Application No: H23-0259-24 **Applicant:** Mr & Mrs S Steward

Proposal: Erection of Salon - Retrospective

Location: Springway Stockwell Gate Whaplode

CASE OFFICER ASSESSMENT

SITE PLAN
1/500

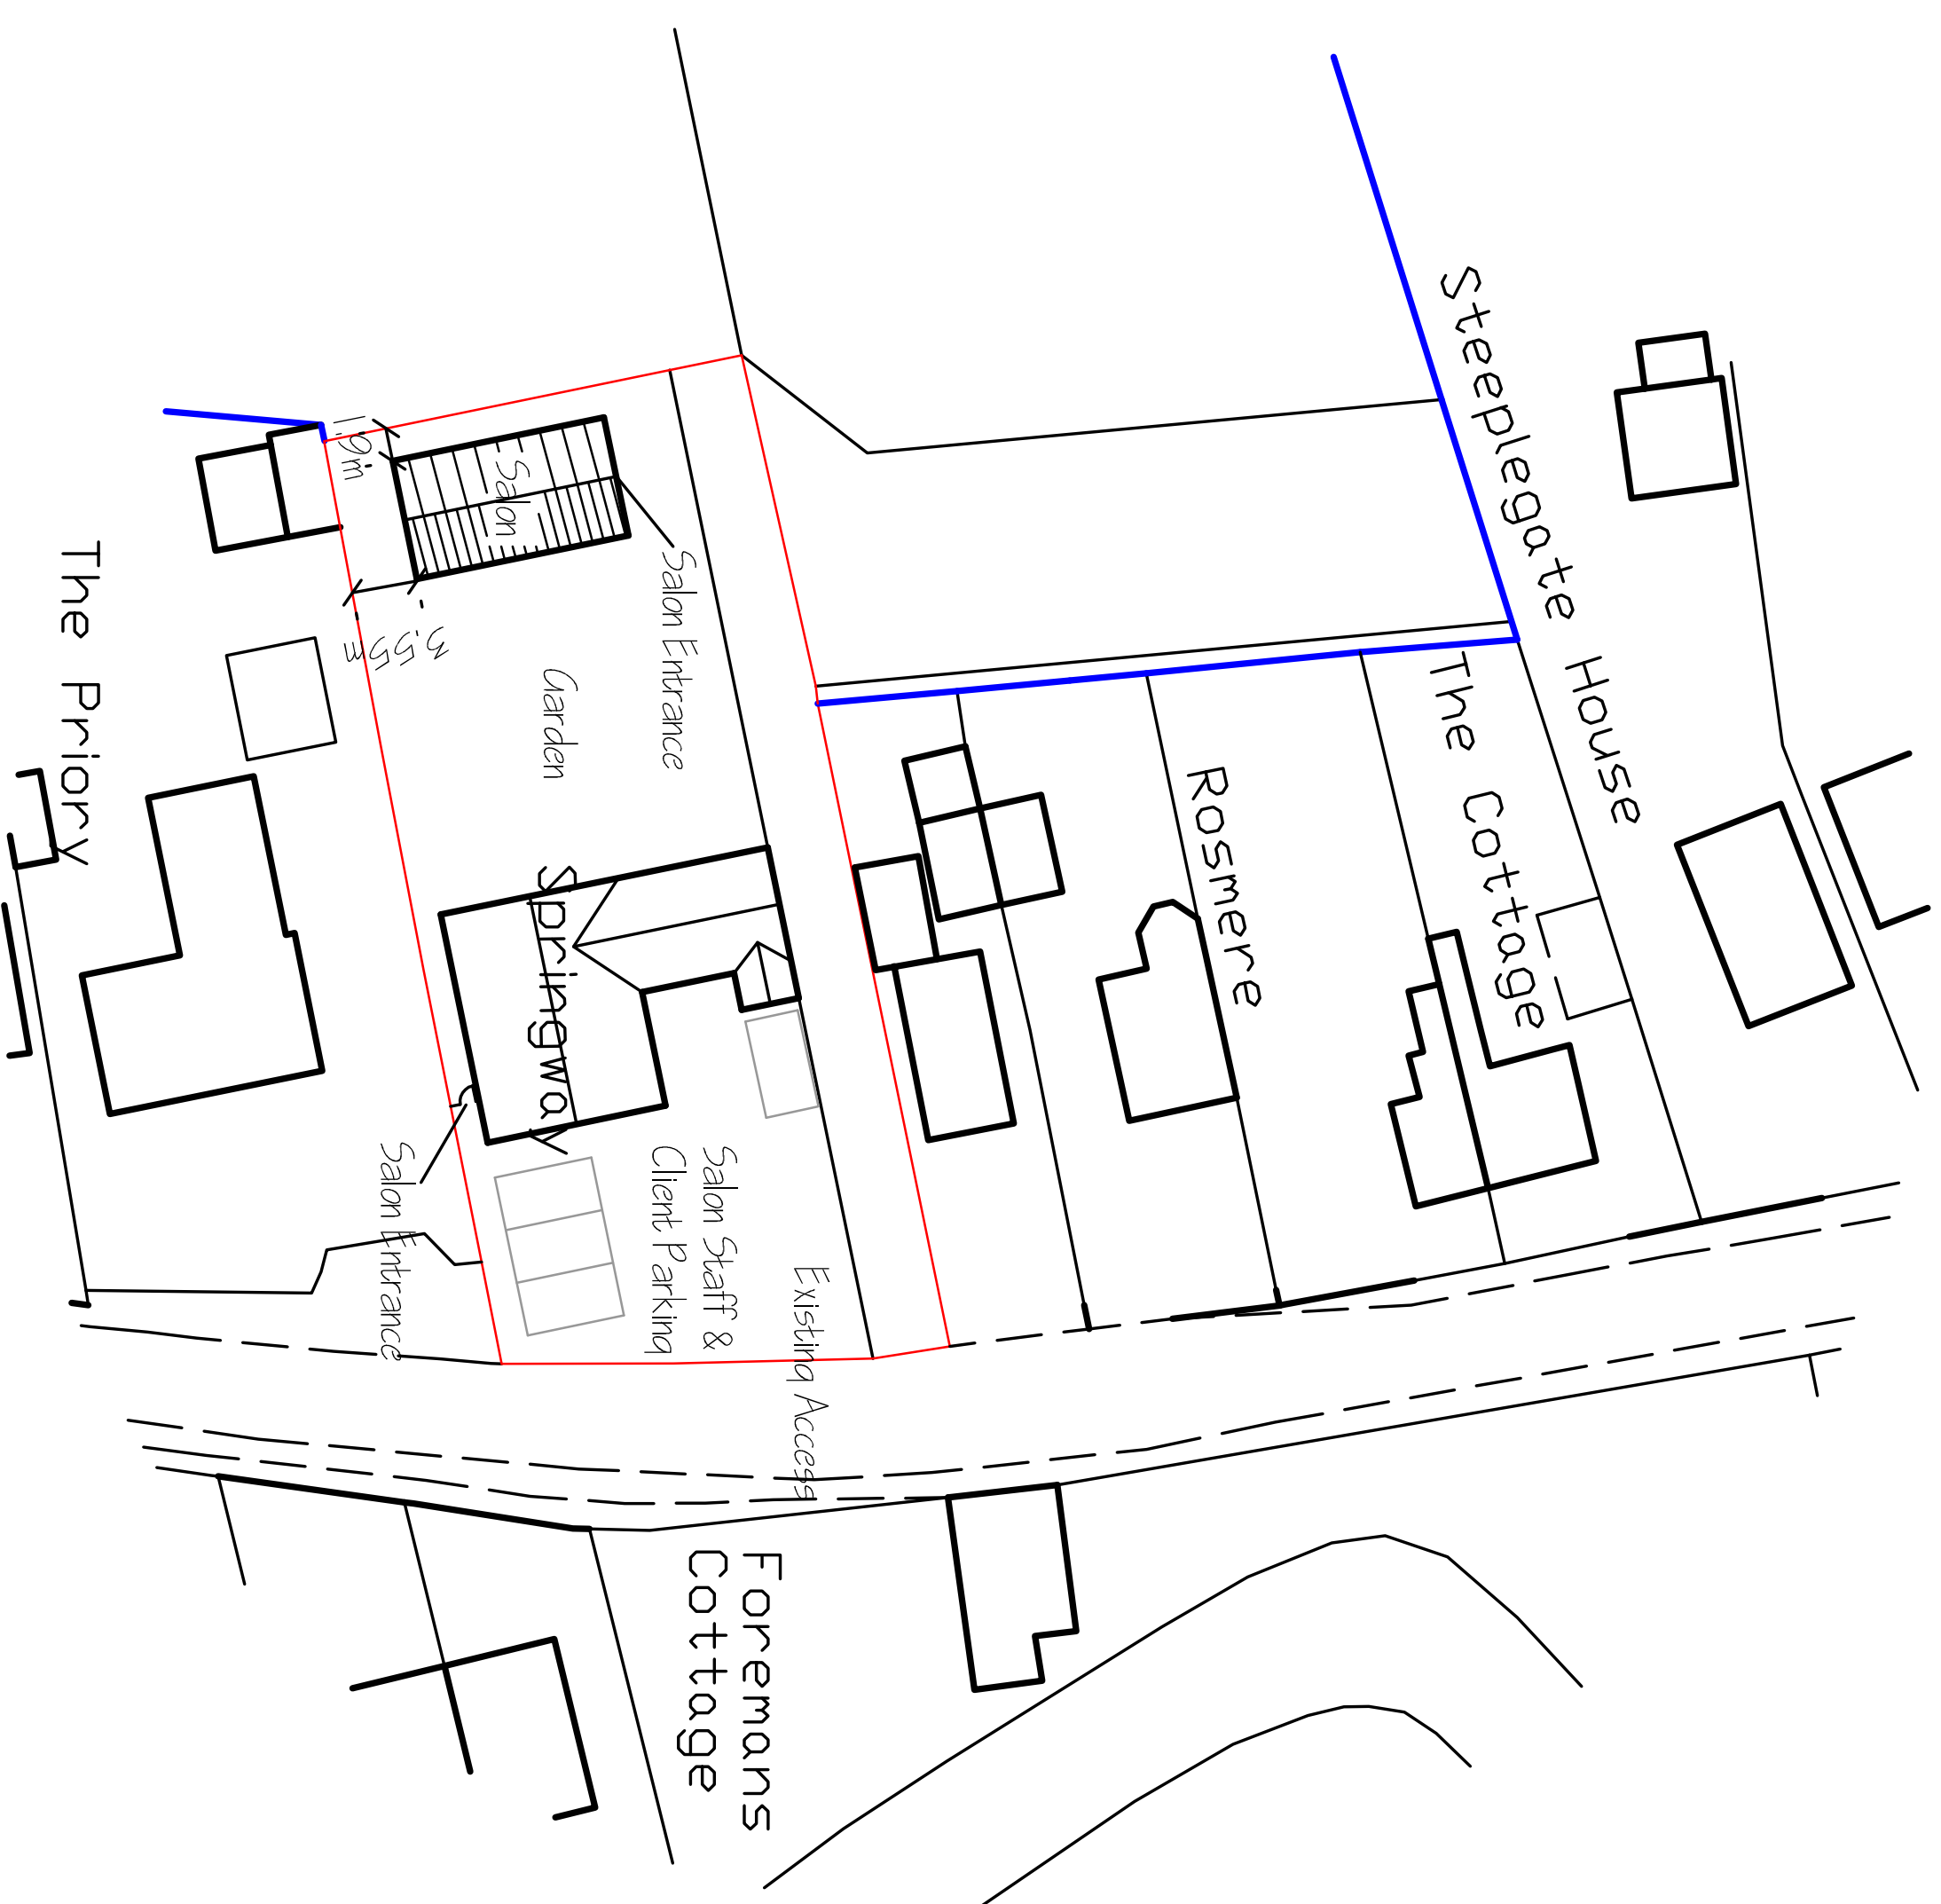
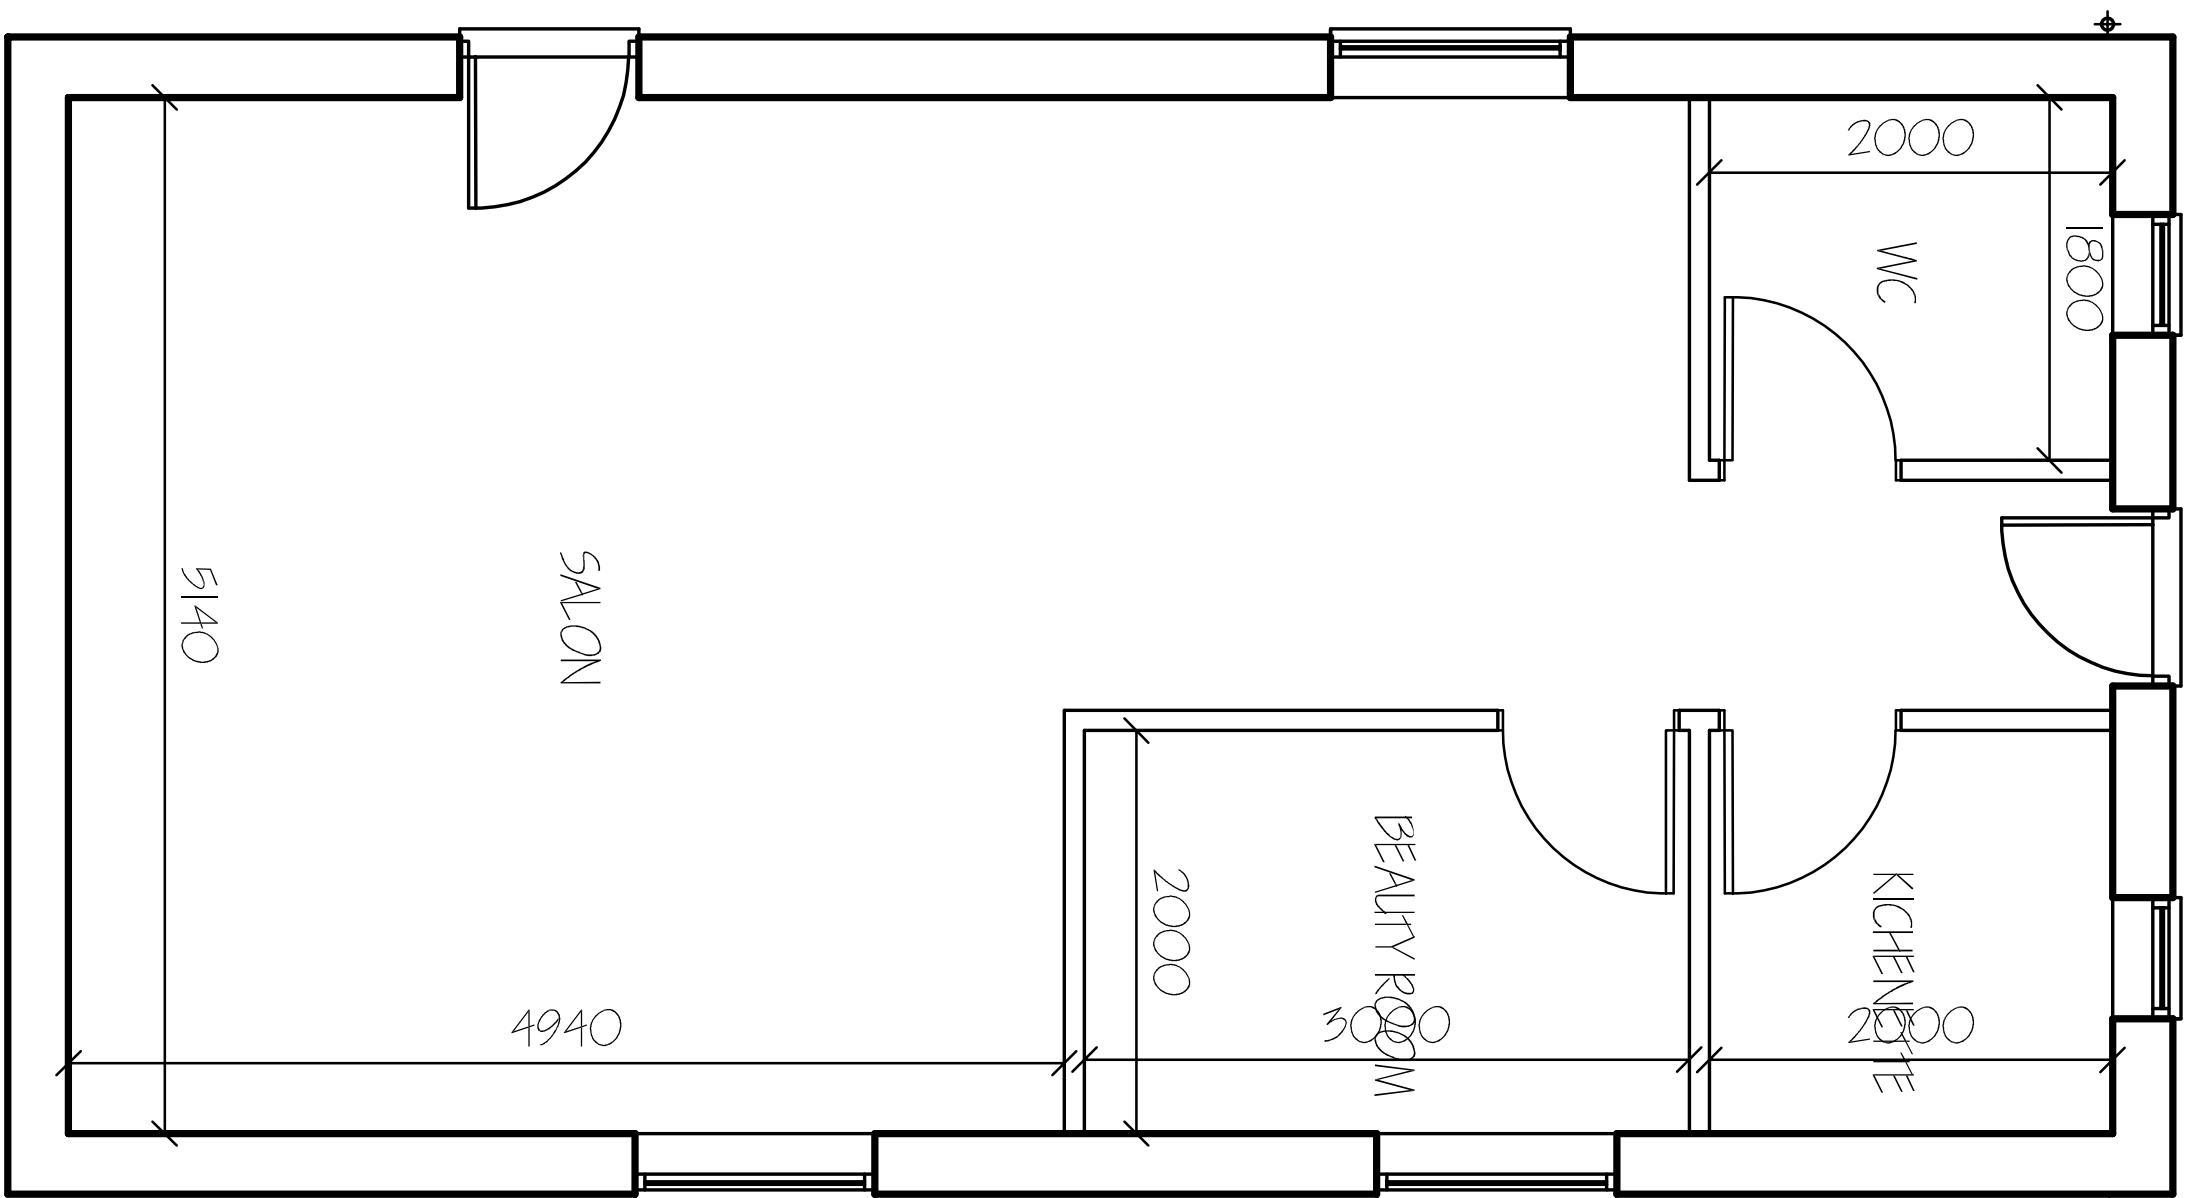
The proposed site plan does not show where visitors to the salon park.

The applicant has submitted an amended plan that shows customers and staff will use the parking area to the front of Springway and access/egress the salon past the walkway next to the house. The salon if managed in the above way, and operated in accordance with the submitted hours would

The applicant has provided an updated site plan showing 3 spaces made available for customers and staff. Sufficient parking provision is retained for domestic use. Highways have requested that this information is provided. Given that the salon would be conditioned that only two customers can be at the salon at any one time and that the planning statement confirms two members of managers, one being Mrs Steward then sufficient parking is provided.
